Application No: FP/262/21/PL  
Site Address: Mast at Felpham Way Bognor Regis PO22 8PS  
Description of works: Erection of EE/H3G 15m High Phase 8 Monopole to replace existing EE/H3G 12.5m Phase 5 Monopole and associated ancillary works. This site is in CIL Zone 4 (Zero Rated) as other development.

Thank you for your internet representation made on 21st January 2022 which has been recorded as an objection with the comments as follows:

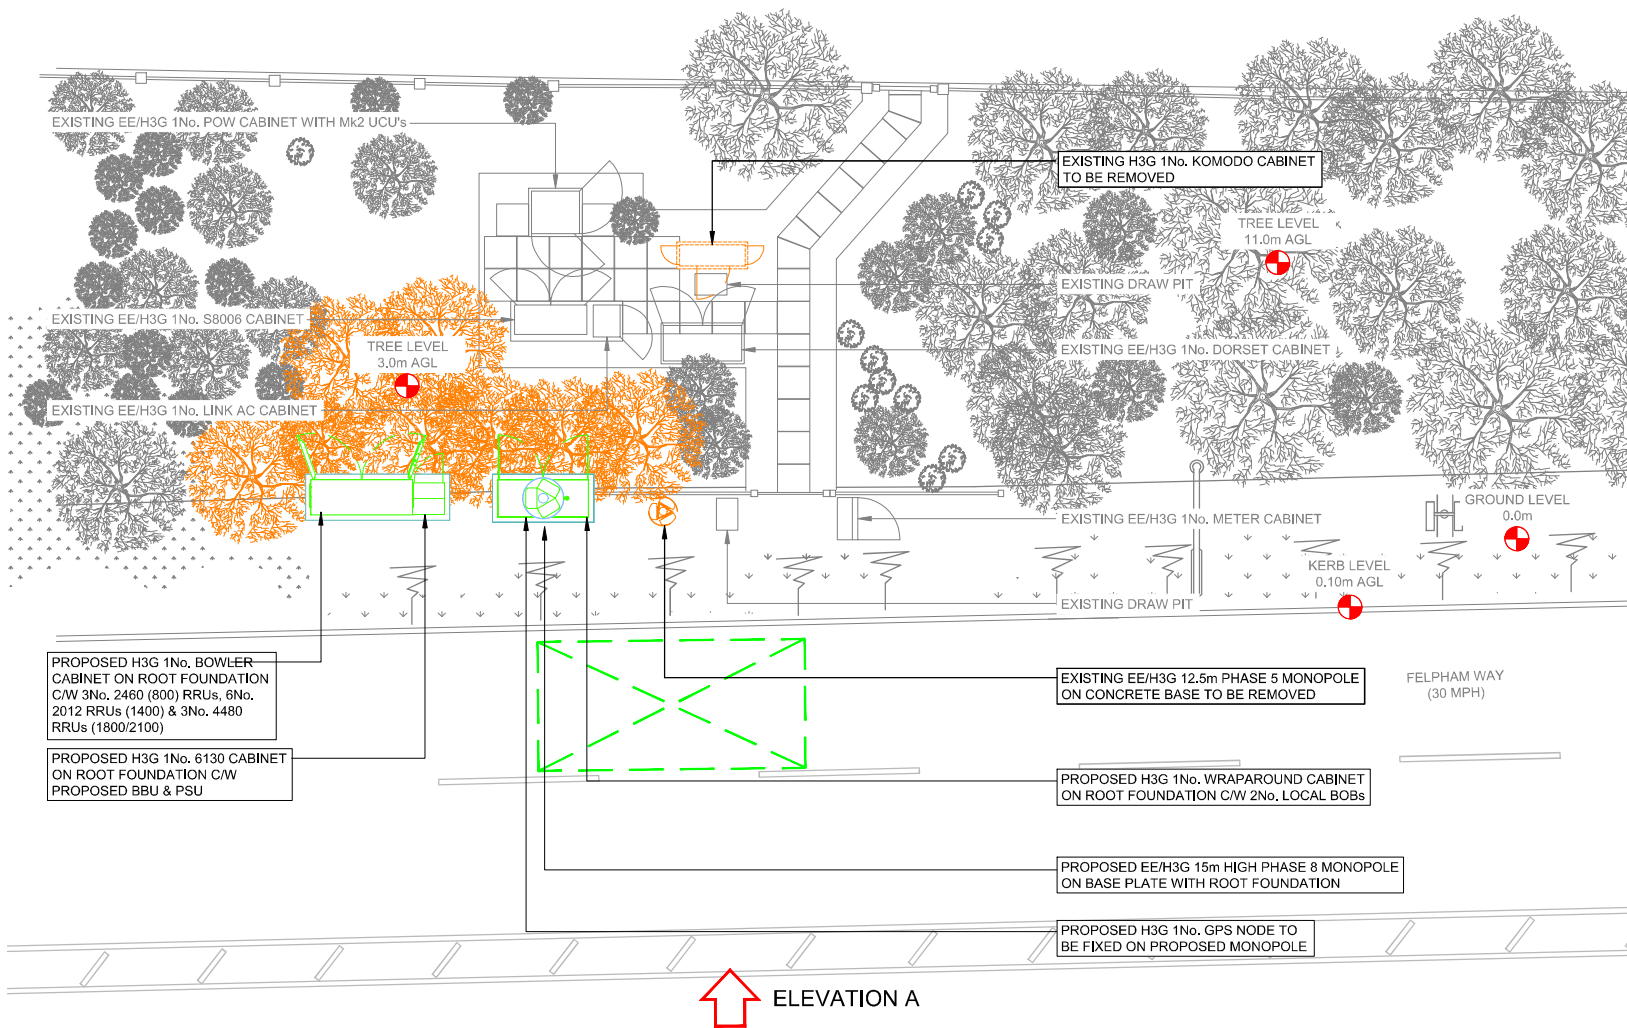
I note the applicant has submitted a 'Tree Information Statement' since the 'comment by' date. The statement they have submitted addresses the location of the proposed pole but not my concerns that were the potential loss of shrubs and trees due to the location of the proposed 2 new cabinets to the west of the new pole. Access to the cabinets through the trees from the north side and the opening of the cabinet doors into the tree area makes it possible that existing shrubs and trees may need to be unnecessarily removed. The location plan shows the boundary of the site, why are the cabinets not to be located within that area, which would probably have considerably less impact on the existing tree screen. Location of the pole on the southern edge of the tree screen is sensible, especially as the existing pole is in that location. Not an objection to the idea of the proposal but objecting to the way it is to be laid out and carried out.
